DECISION DELEGATED TO HEAD OF PLANNING

Application No:	H09-1089-21	Applicant:	Mr & Mrs C Parker
Proposal:	Alterations, Single Storey Extension and Garage		
Location:	52 Spalding Road Holbeach Spalding		
Terminal Date:	14th January 2022

ATTIC FLOOR PLAN - SECTIONS - PROPOSED

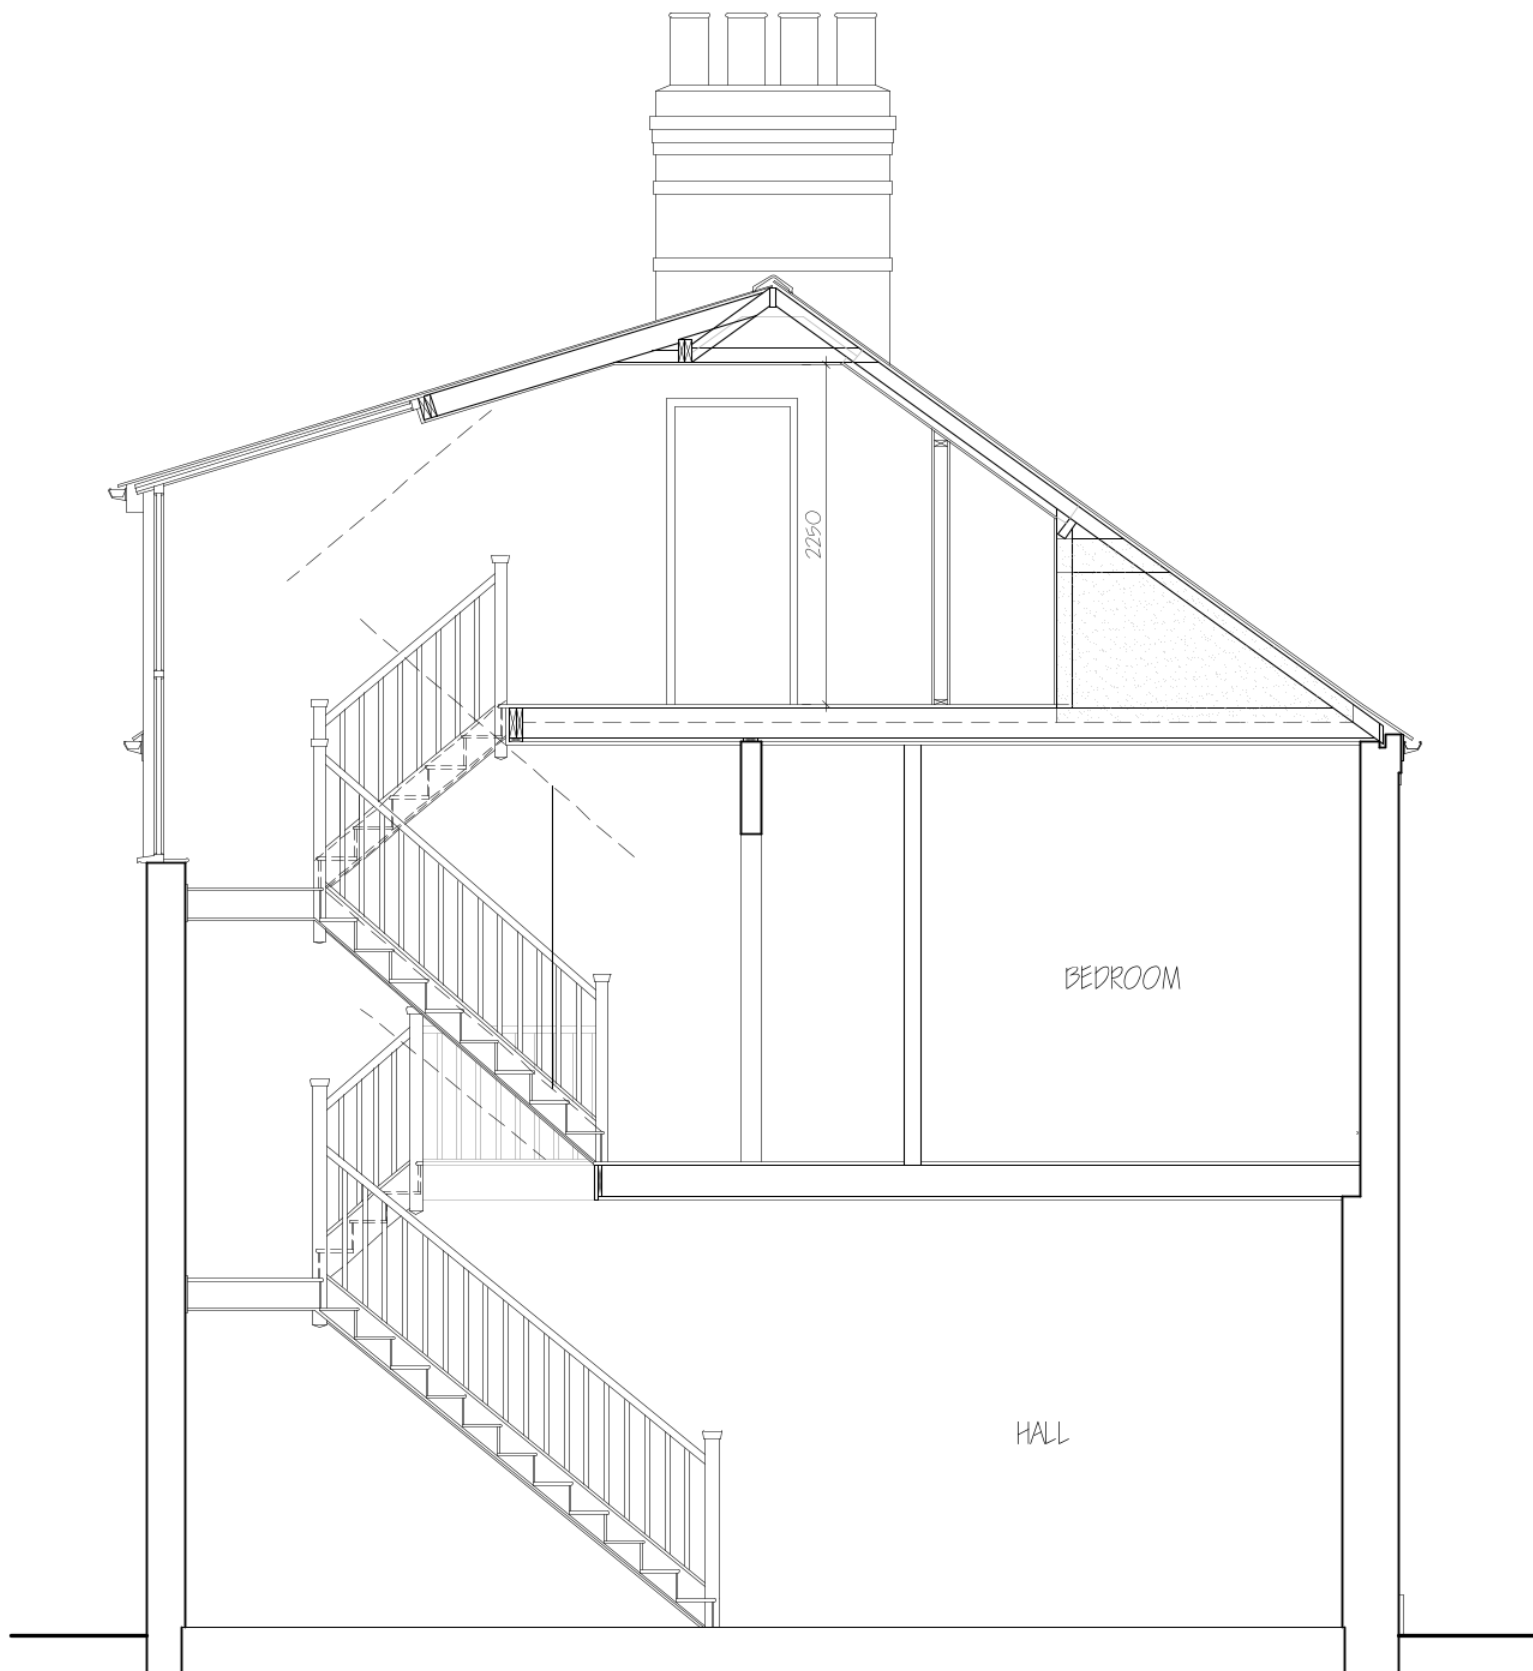
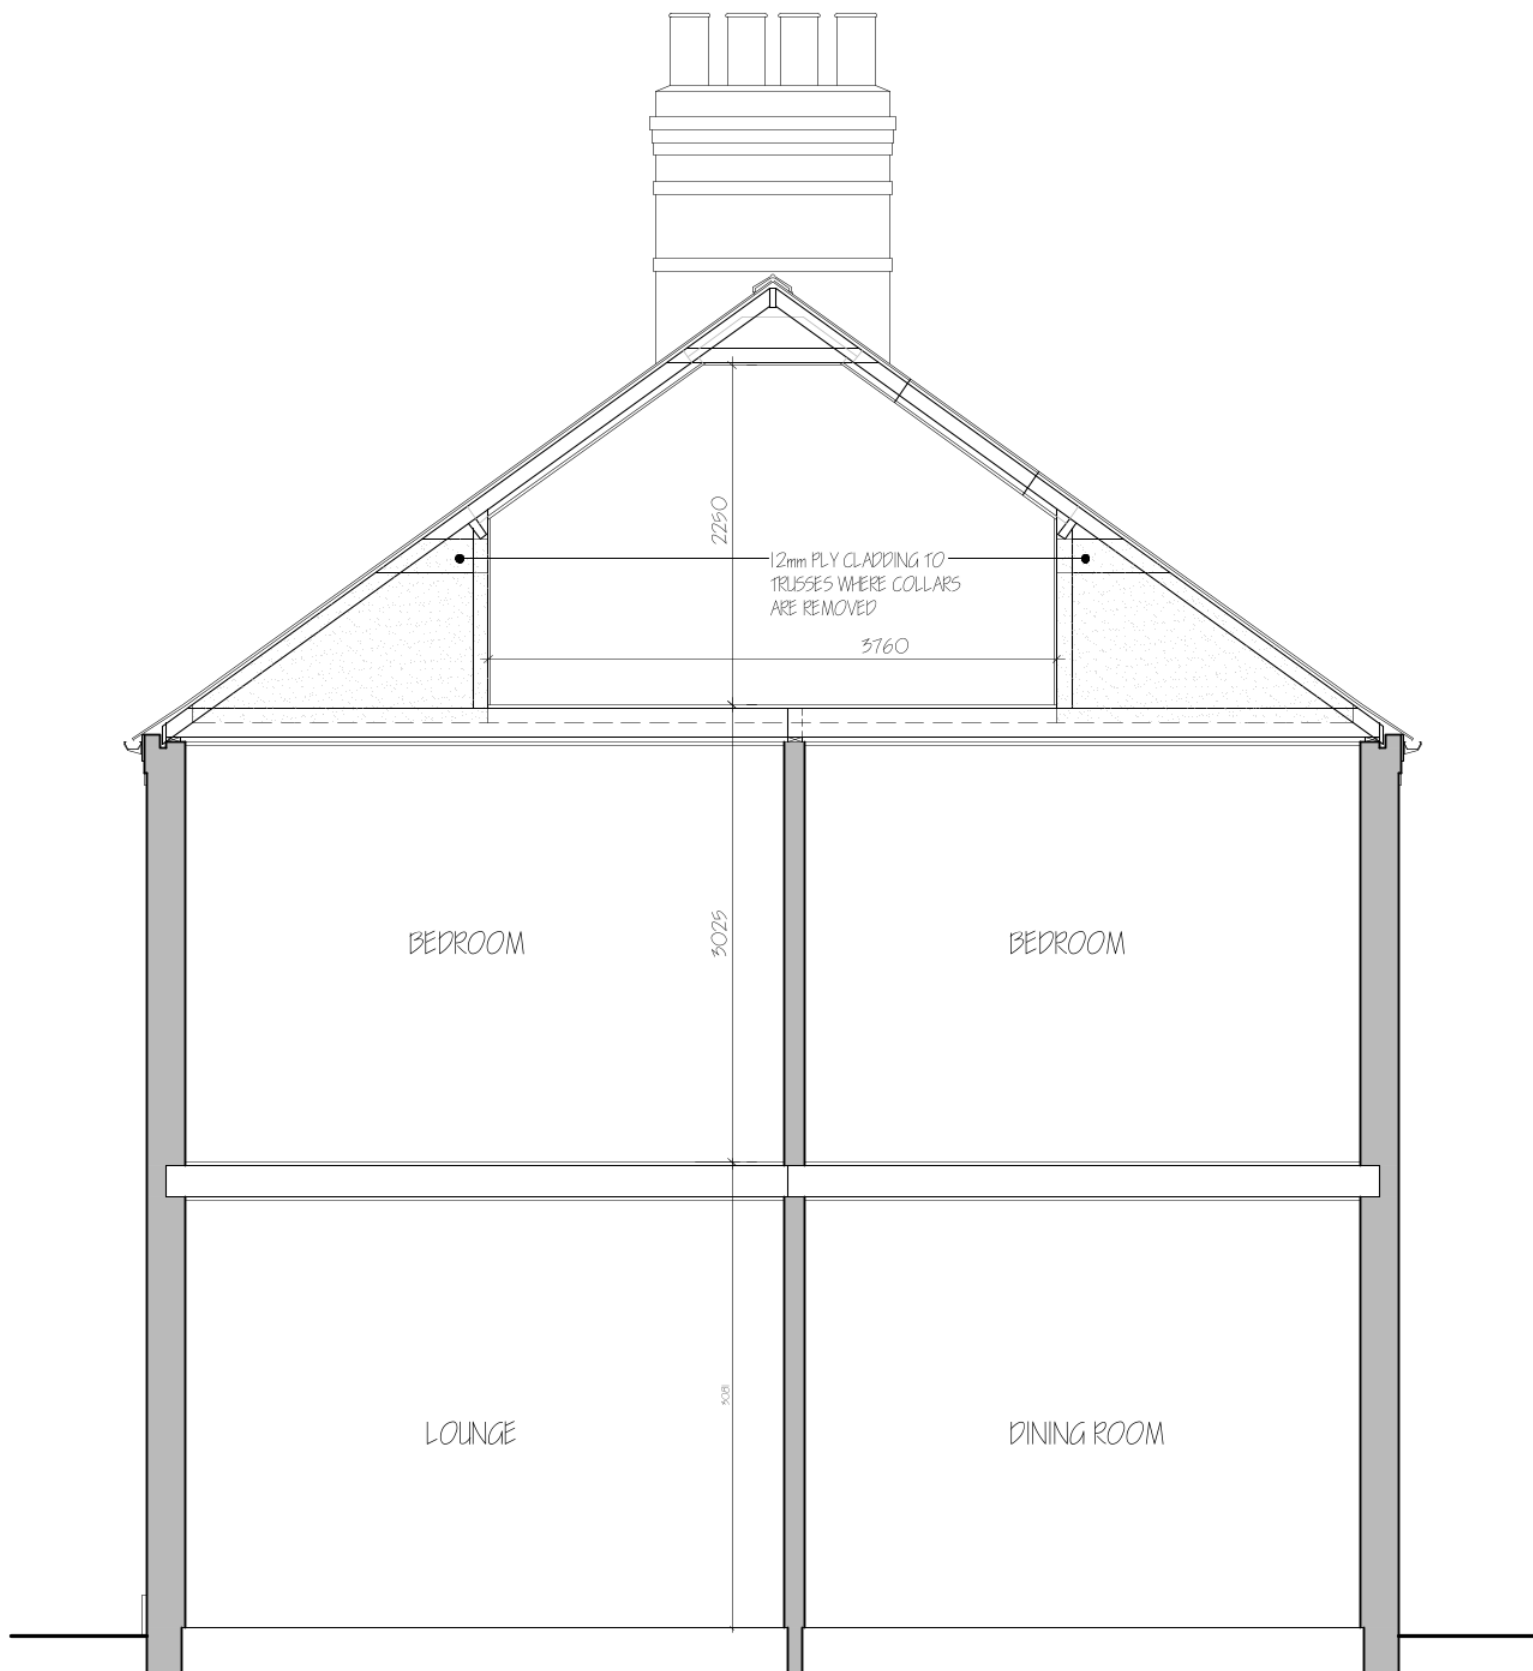
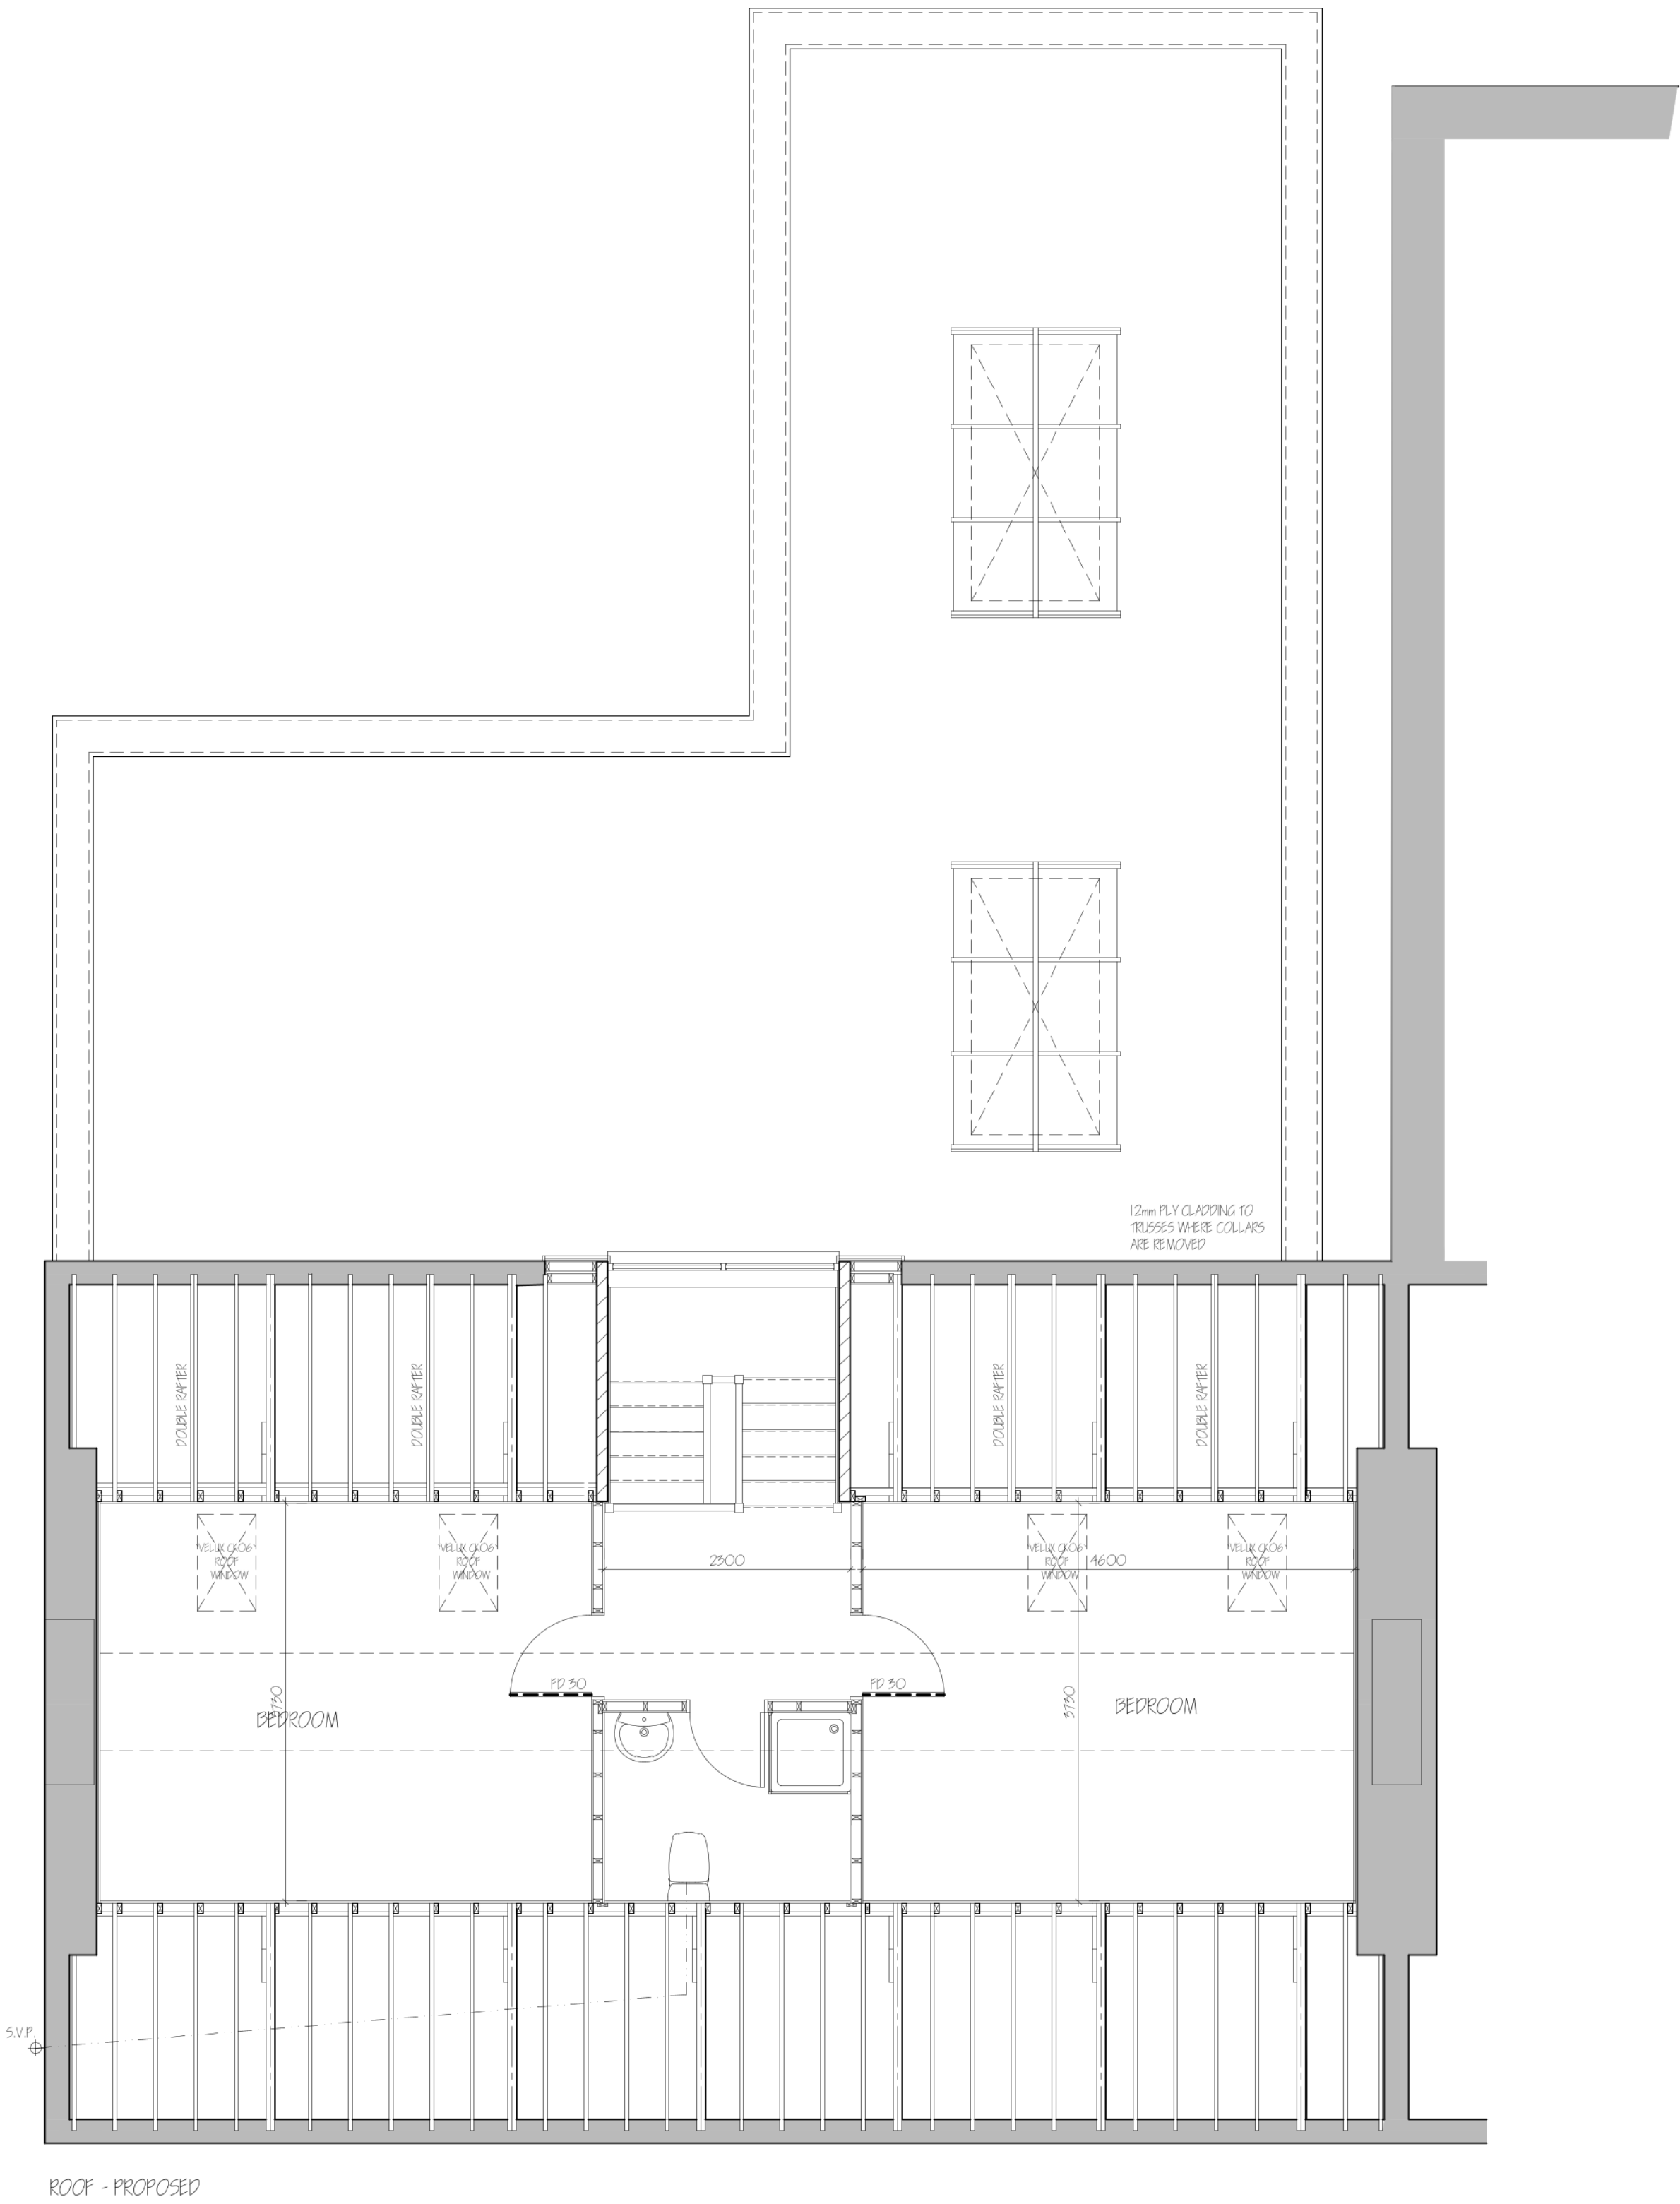
The proposed loft conversion and rooflights can be done under permitted development therefore this element could not be reasonably resisted. In any case the new windows in the loft would offer

similar views to the existing first floor windows in the rear elevation therefore it is not considered that this element would result in any increased overlooking or loss of privacy.
